Comments on the Applicant's D5 Submissions

This document sets out the comments on the Applicant's Deadline 5 (D5) submissions by Cambridgeshire County Council (**CCC**). The tables below set out the document in question that the Council is commenting on, together with the relevant paragraph or reference number.

6.2 Appendix 13C Framework Construction Traffic Management Plan and Travel Plan (Tracked) - Rev: 04 [REP5-015] and all Appendices (A to G) [REP5-016 to REP5-042]

ACM-60589004-AMR-DR-0037

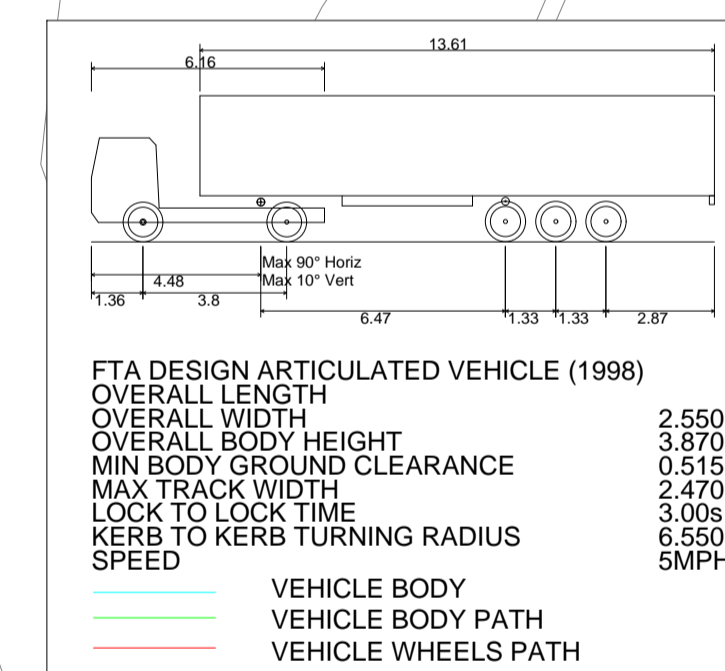
Plan ACM-60589004-AMR-DR-0037	Cable Route Access L. A142 - Newmarket Road, Fordham.	<p>Point 1.3.1 of 6.2 Appendix 13C Framework Construction Traffic Management Plan and Travel Plan - Rev: 04 indicates the removal of Grid Connection Site Access L (CR-L) from the Scheme, with access to the Cable Route corridor being taken solely from Grid Connection Site Access K (CR-K), We note details related to this access remain in the CTMP.</p> <p>Access L was to utilise an existing access onto the A142, that appears to have been designed to the appropriate standards to accommodate the movement of HGVs. While visibility splays have not been detailed on the plan and should be provided for confirmation, it is anticipated that appropriate distances can be achieved.</p>
Plan ACM-60589004-AMR-DR-0038	Cable Route Access M. Chippenham Road / Snailwell Road, Chippenham	<p>The proposal is to utilise an existing unmade field access with improvements including 10m radius to the east and 6m radius to the west, although no form of construction is detailed.</p> <p>The swept path detail shown does not demonstrate the ability for two vehicles to pass, and while vehicle movements will be managed during the operational phase to avoid opposing flows, it is unclear how the access will be used during the operational phase, or how such conflict will then be managed. It is therefore unclear whether safe access is provided.</p> <p>No visibility splays have been detailed to demonstrate that visibility appropriate to the speed of the road can be achieved within the DCO or Highway boundary. Chippenham Road is planted with low trees to the west and with a dense hedge to the east, creating a significant risks obstruction of visibility. It is not therefore possible to confirm that safe access can be achieved.</p>

ACM-60589004-AMR-DR-0038

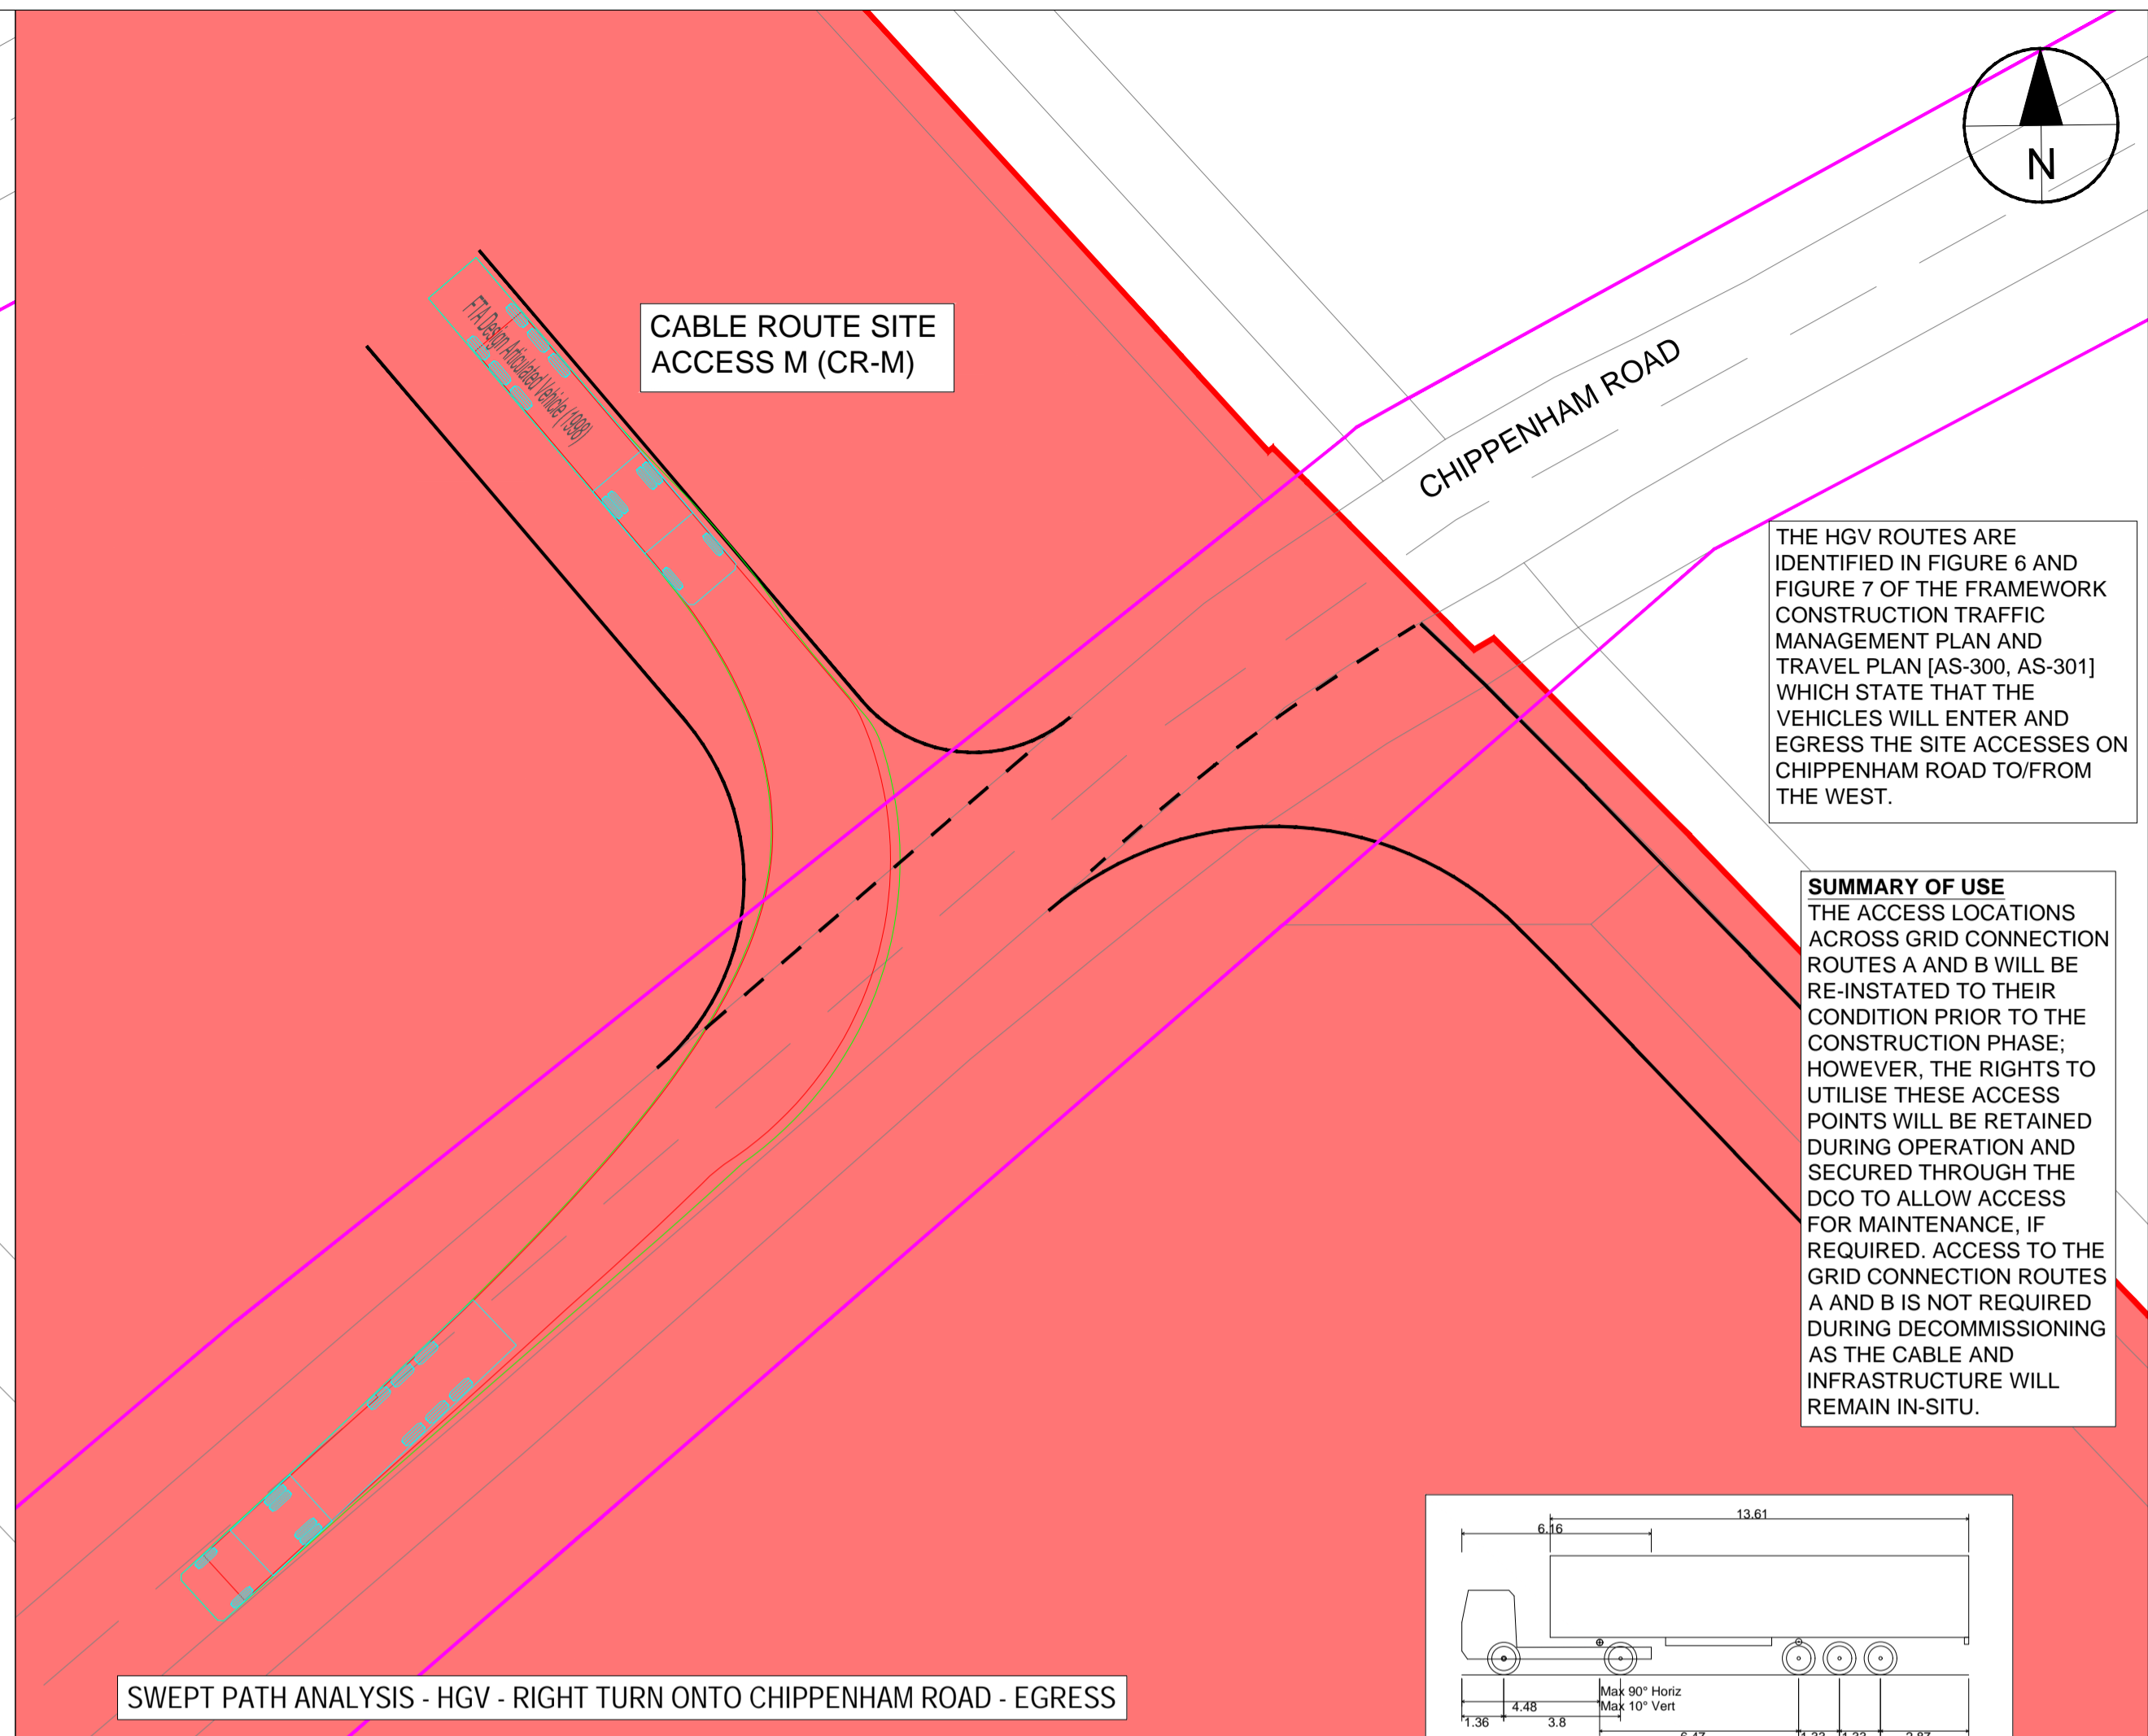
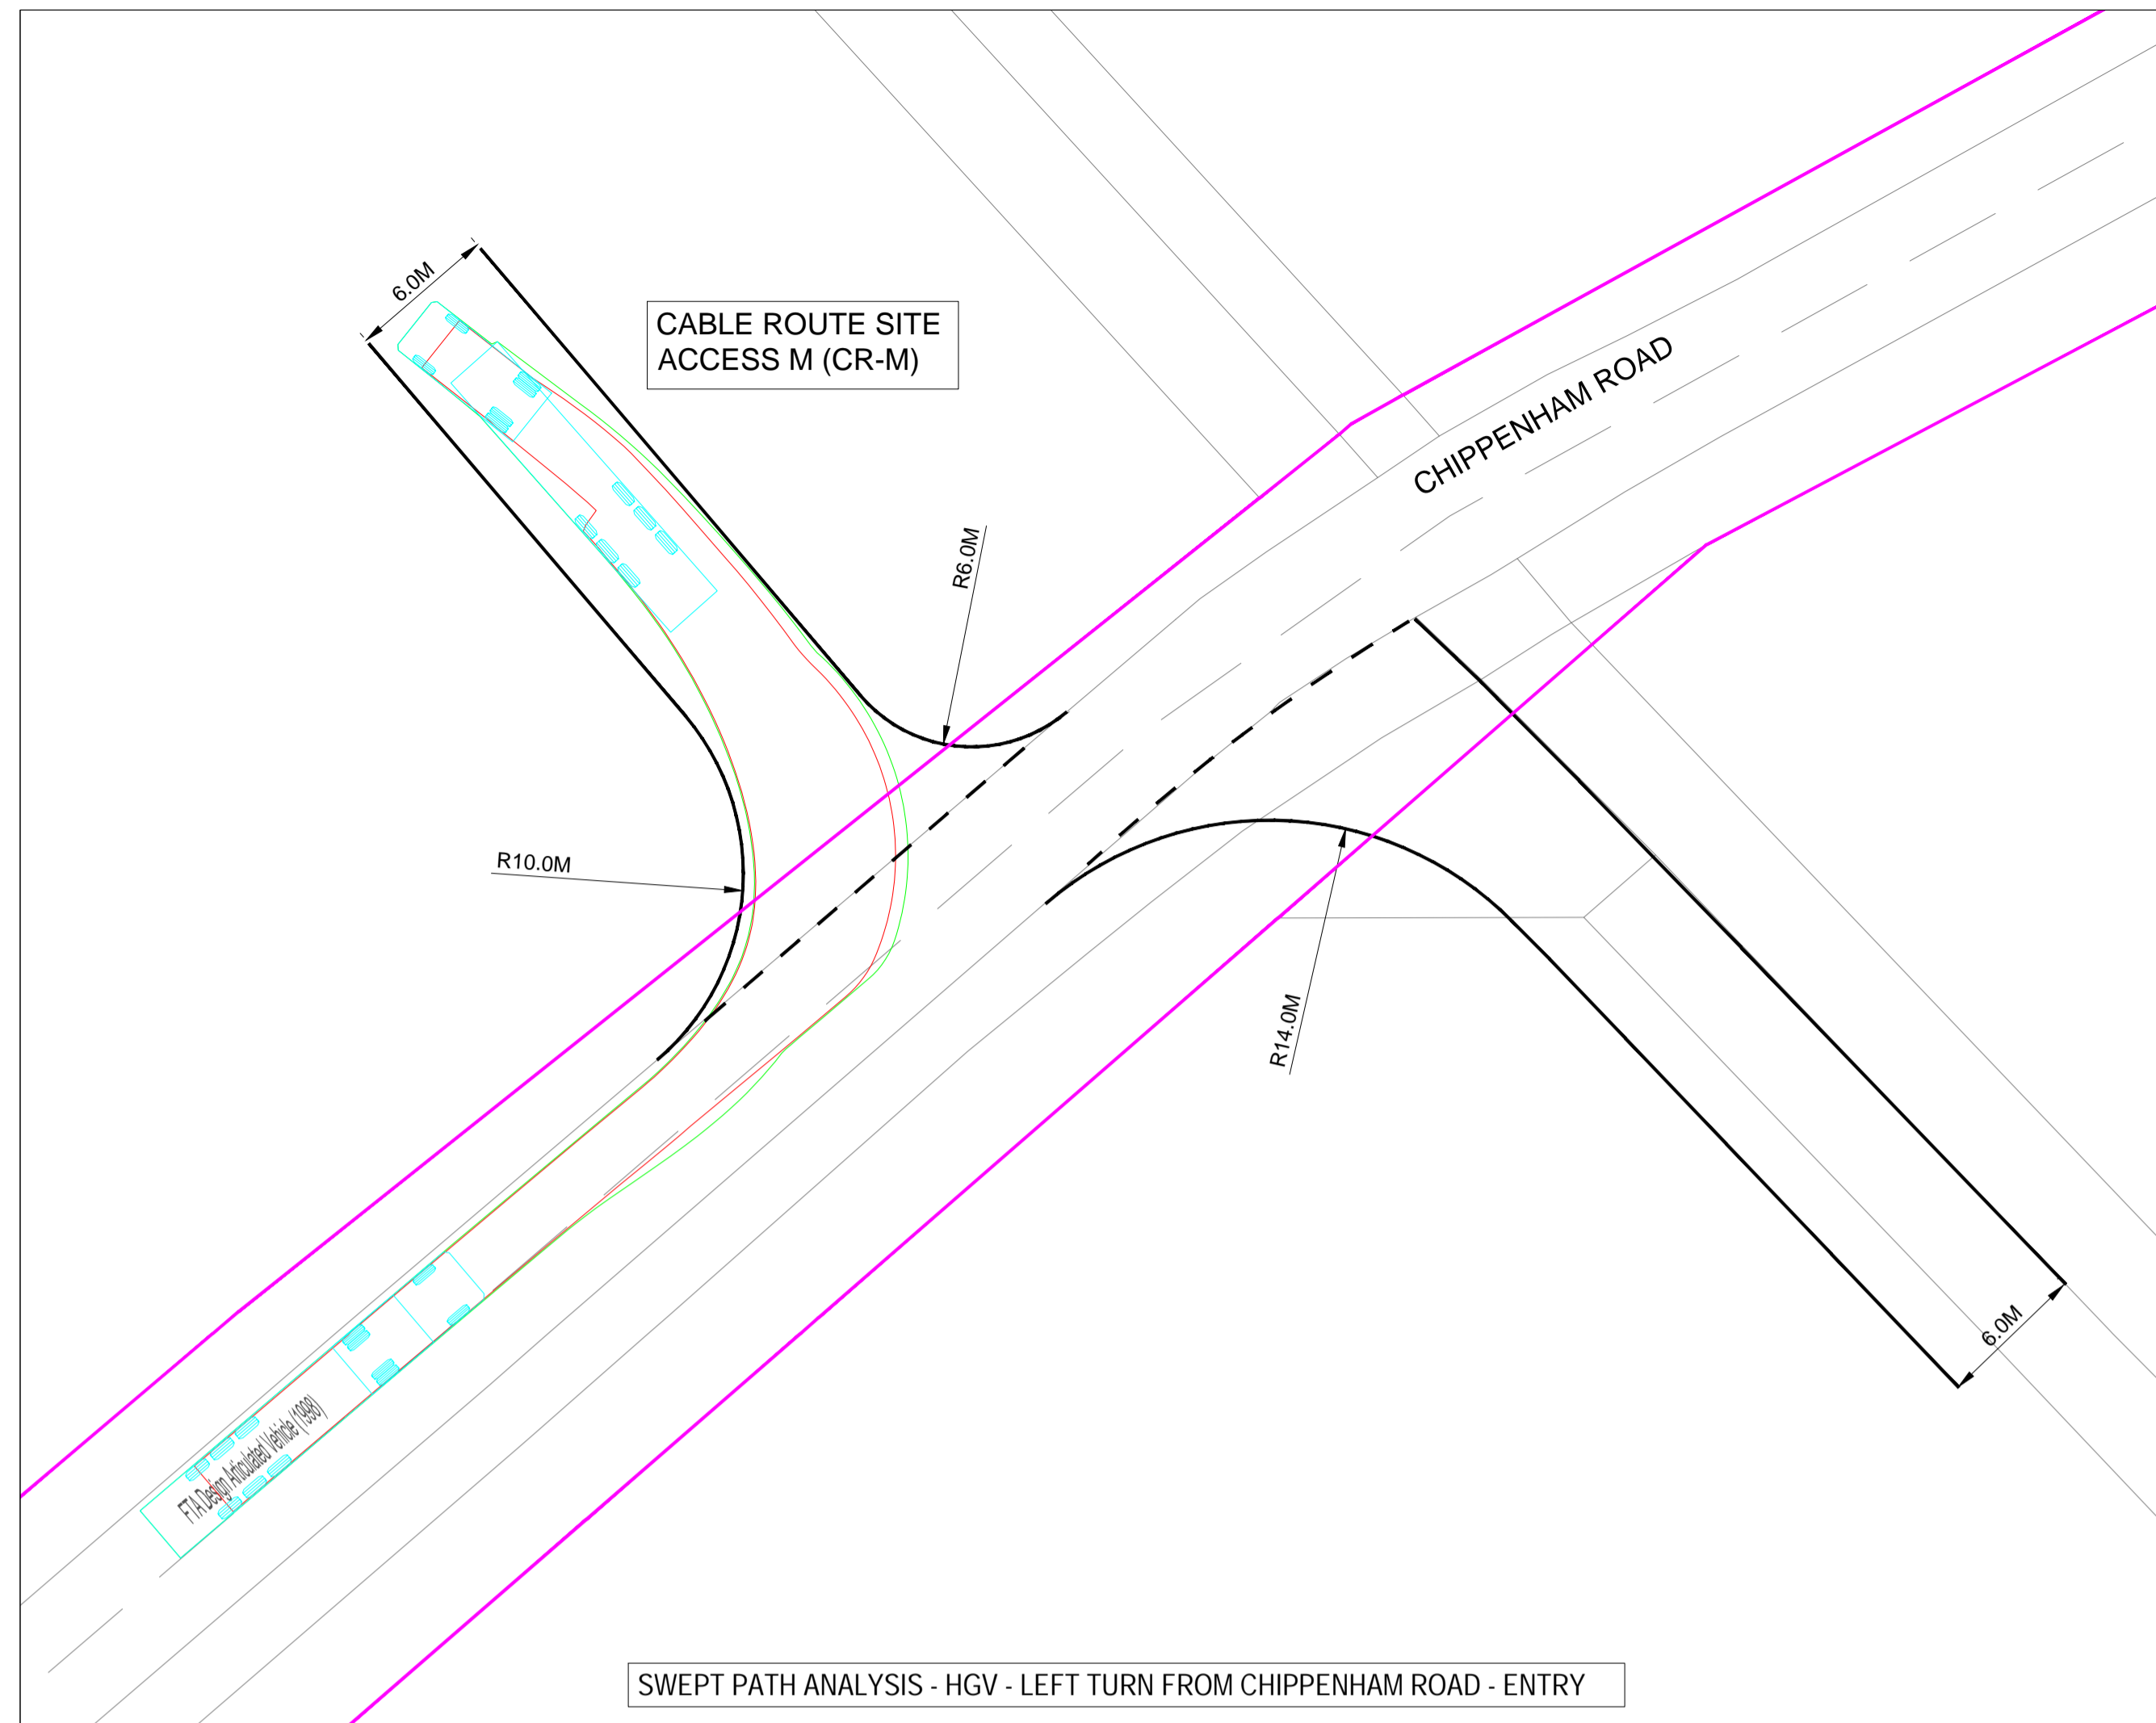
Plan ACM-60589004-AMR-DR-0038	Cable Route Access N. Snailwell Road, Chippenham.	<p>The proposal is to utilise an existing unmade field access, with improvements including 14m radius to the east but no radius to the west. This would not be considered acceptable unless it can be proven that traffic will not enter the access from the east during any phase of its use. It is also noted that any radius on the eastern side would conflict with an adjacent access and any proposal would therefore need to accommodate this.</p> <p>The swept path detail shown does not demonstrate the ability for two vehicles to pass, and while vehicle movements will be managed during the operational phase to avoid opposing flows, it is unclear how the access will be used during the operational phase, or how such conflict will then be managed. It is therefore unclear whether safe access is provided.</p>

<p>No visibility splays have been detailed to demonstrate that visibility appropriate to the speed of the road can be achieved within the DCO or Highway boundary. Chippenham Road is planted with low trees to the west and with a dense hedge to the east, creating a significant risks obstruction of visibility; this is of particular concern to the east, with this access located on the inside of the bend. It is not therefore possible to confirm that safe access can be achieved</p>
Plan ACM-60589004-AMR-DR-0038	Cable Route Access O. La Hough Road, Chippenham.	<p>The proposal is to utilise an existing unmade access which it appears to share with an existing dwelling. Improvements are proposed, with 12m radius to the east and 6m radius to the west, which appear broadly acceptable for the use and speed of the road.</p> <p>The swept path detail shown does not demonstrate the ability for two vehicles to pass, and while movement will be managed by traffic signals during the construction phase, it is unclear how the access will be used during the operational phase, or how such conflict will then be managed. It is therefore unclear whether safe access is provided.</p> <p>No visibility splays have been detailed to demonstrate that visibility appropriate to the speed of the road can be achieved within the DCO or Highway boundary. It is not therefore possible to confirm that safe access can be achieved during the operational phase in the absence of traffic management.</p>
